Ms. Lauren Anderson
Planner
City of Mercer Island, Community Planning and Development

June 15, 2020

Re: Permit No. 2001-188 (building) and No. Sub 18-005 (short plat)
4270 East Mercer Way

Thank you for giving us the opportunity to respond to the comment letter dated June 10, 2020. Below please find the original text and our responses:

**CONTENTS**  
 Foundation Plan

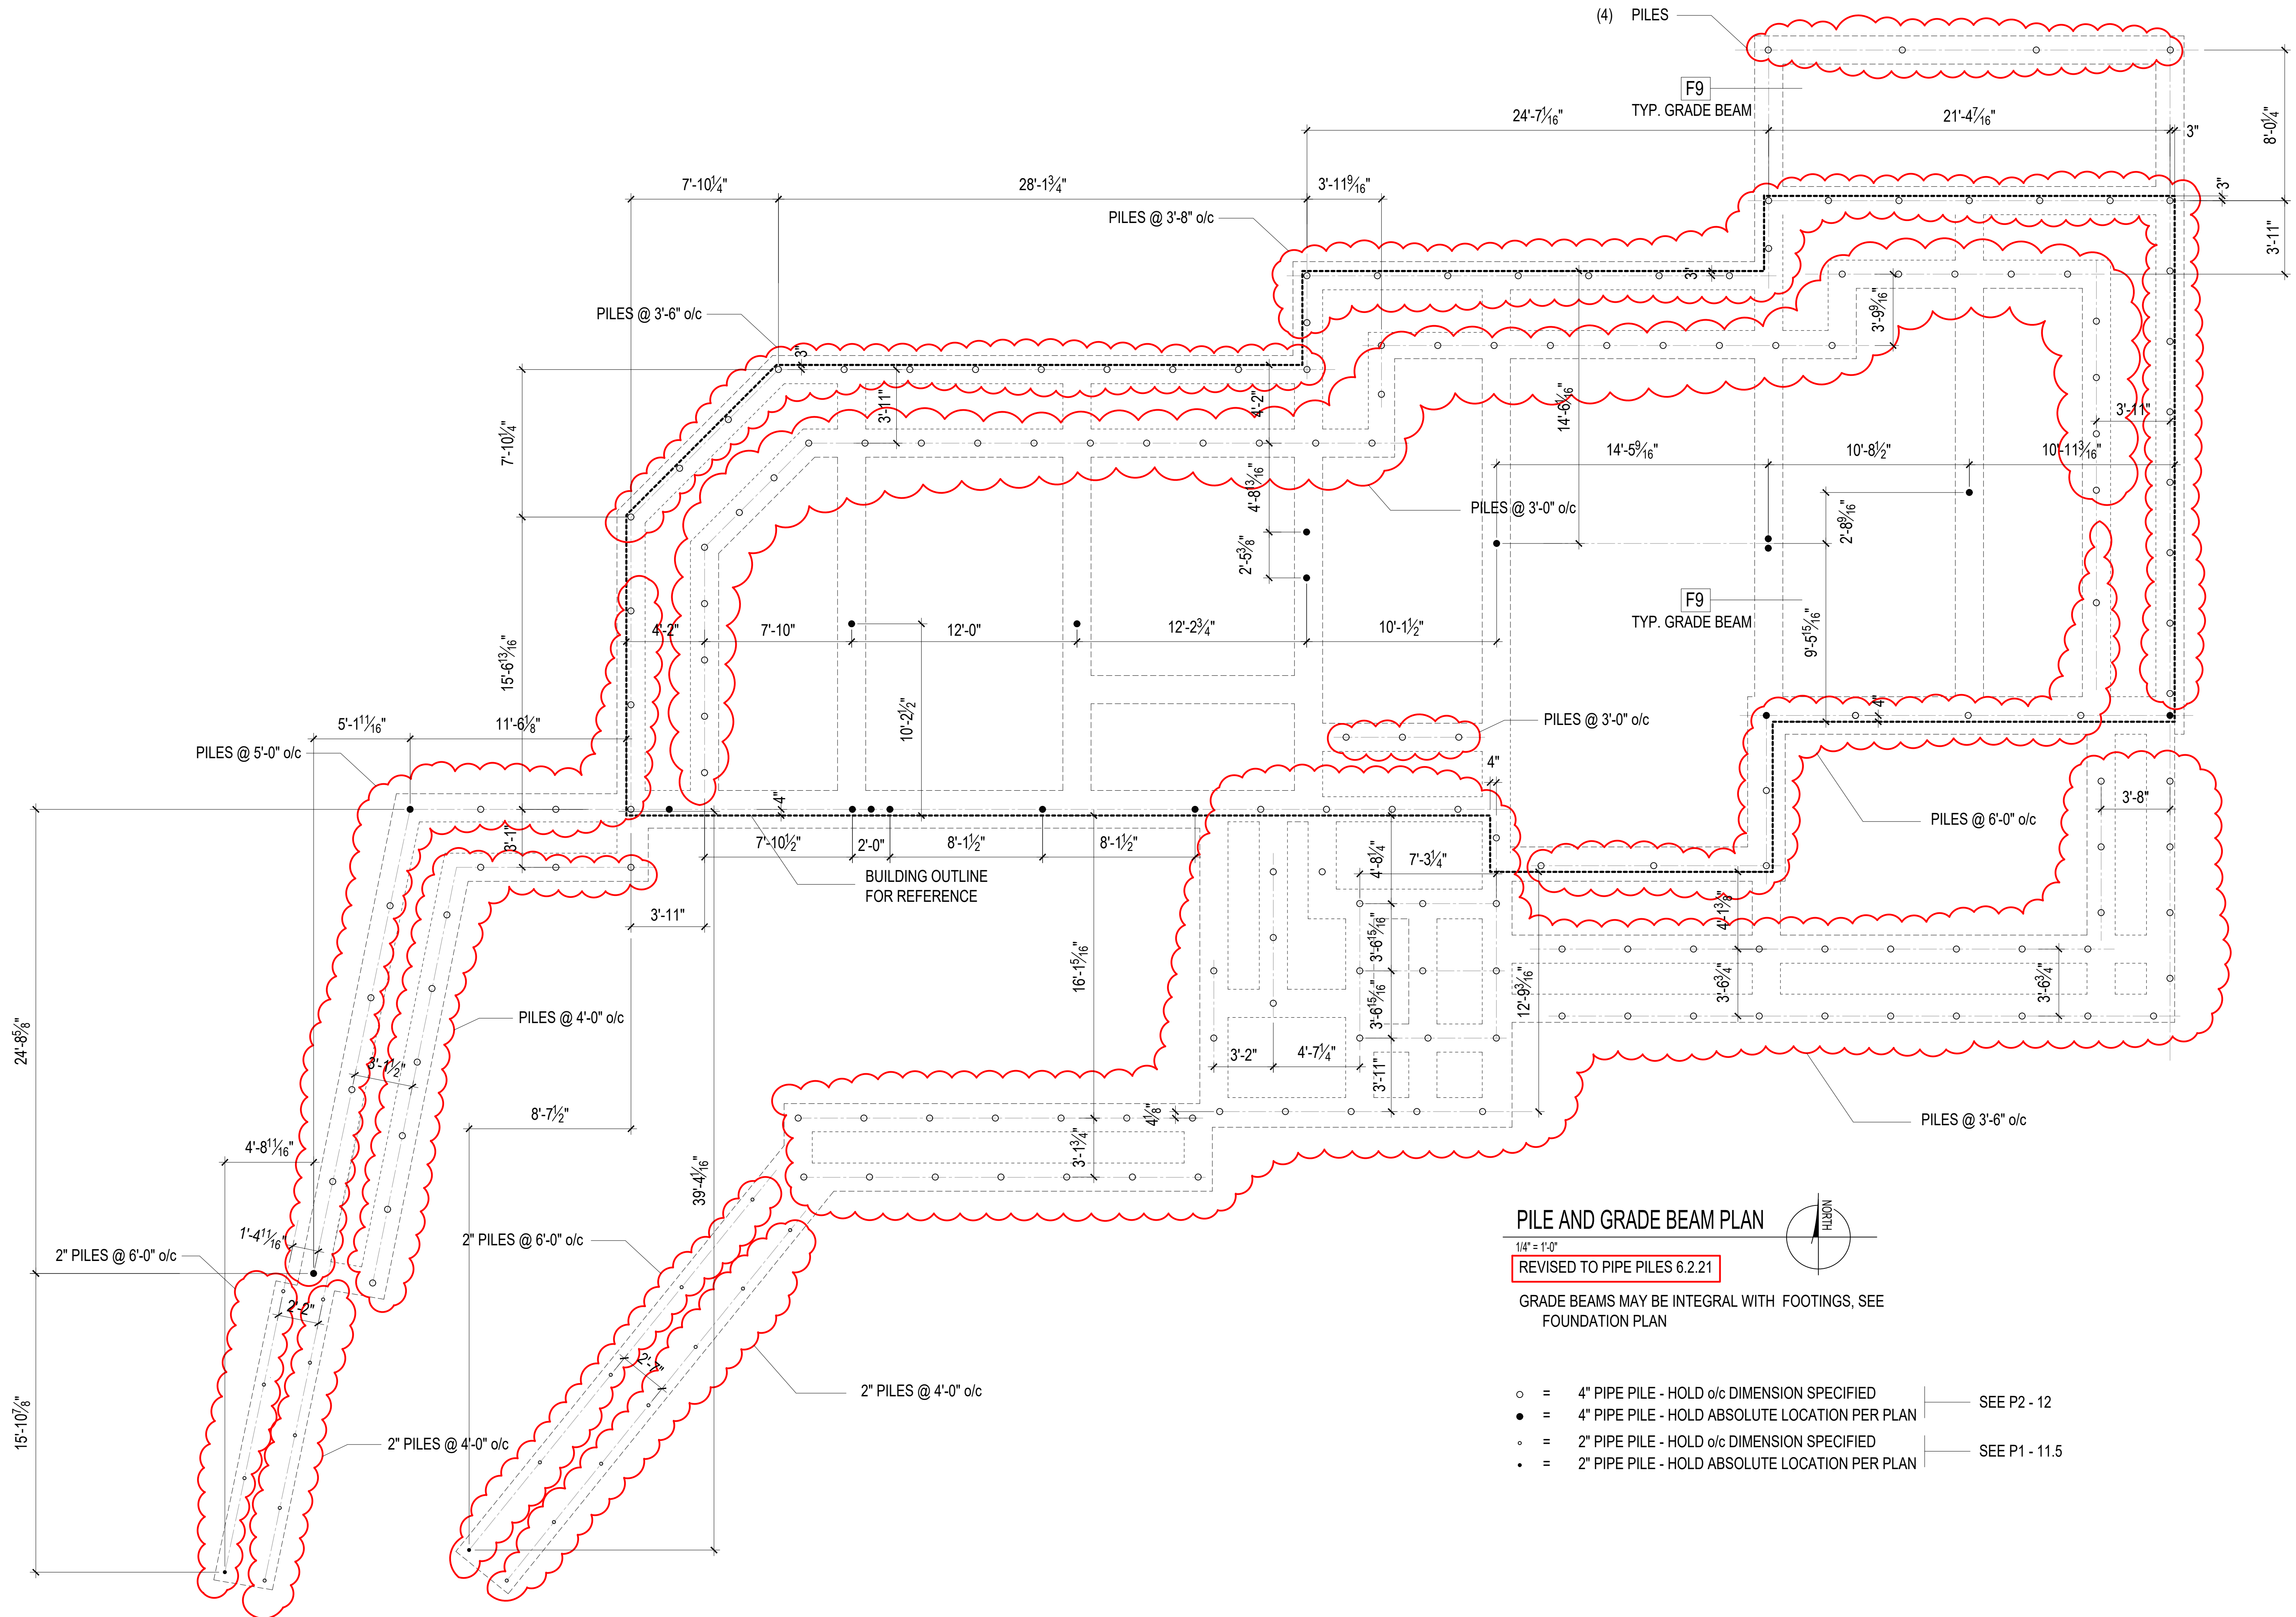
Third, we are concerned that construction of the proposed building will require the removal of two large Lawson Cypress trees (trees #1 and #2) which are important for stabilizing the lot's critical slope. The proposed excavation plan for the building and the storm drain line, as shown in sheet 15, appears to overlap the trees' root area; if excavation is permitted, therefore, the trees will be destroyed. The City Arborist appears to agree that this would be the case and that it is unacceptable, as reflected in his intake comments: "Trees 1 and 2 have new 8" storm pipe and grading within Arborist given limits of disturbance. Either move utilities and grading. Or have air excavation give final limits of excavation. This air excavation to be supervised and memo produced by Project Arborist." Given the significant size of trees # 1 and #2, the nature of the slope and the trees' importance in stabilizing it, as well as the availability of other building sites on the lot, we believe the permit should not be granted in its present form under MICC 19.09.090.A.1.a.

Response: The stability of the slope will be determined by geotechnical analysis and subject to 3rd party reviewer and is not contingent on the maintenance of trees 1 and 2. Because of the proximity to the lines, John Kenny is correct in noting that should they remain they would be unlikely to survive, which is why we opted for removal. Despite the fact that we are removing less than half of the trees allowed by development rules (30% are required to remain, we have maintained over 74%) we will be adding 36 new trees.
